A38 Derby Junctions - TR010022

Evidence on Access Matters for Euro Garages Ltd

October 2019

Doc Ref: WB/14368/FinalPoE/1

### Entry/Egress with A38 NB Diverge Slip road Sketch

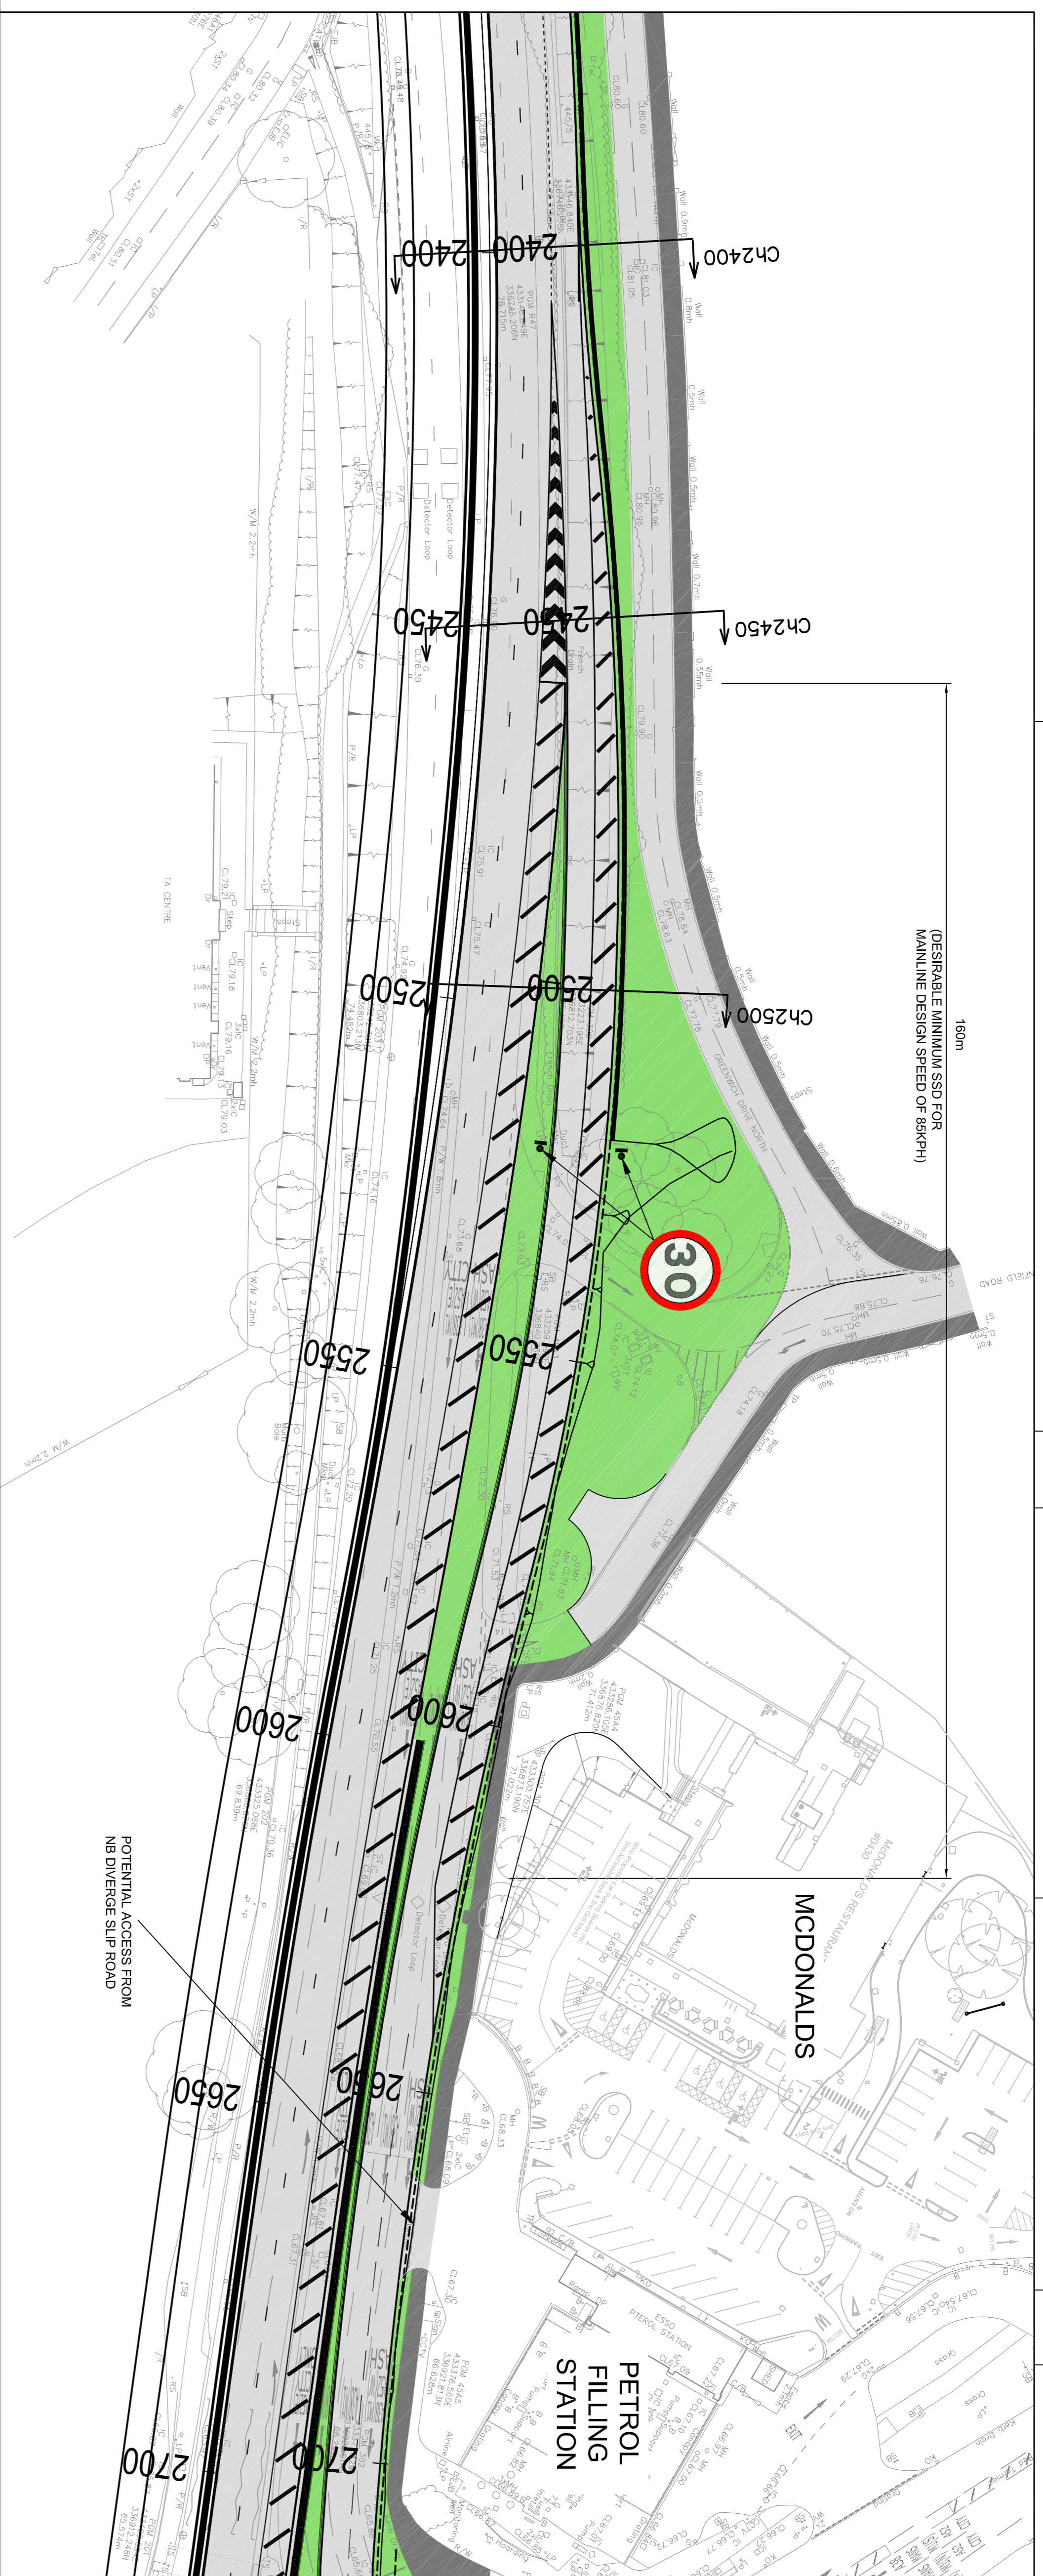
- 4.4 In terms of the proposed removal of the ingress from the A38 it is considered that in geometric terms an ingress could still be provided to the site from the slip road and this provision would leave EG in no worse position that it is currently in with regards to physical access from the A38.
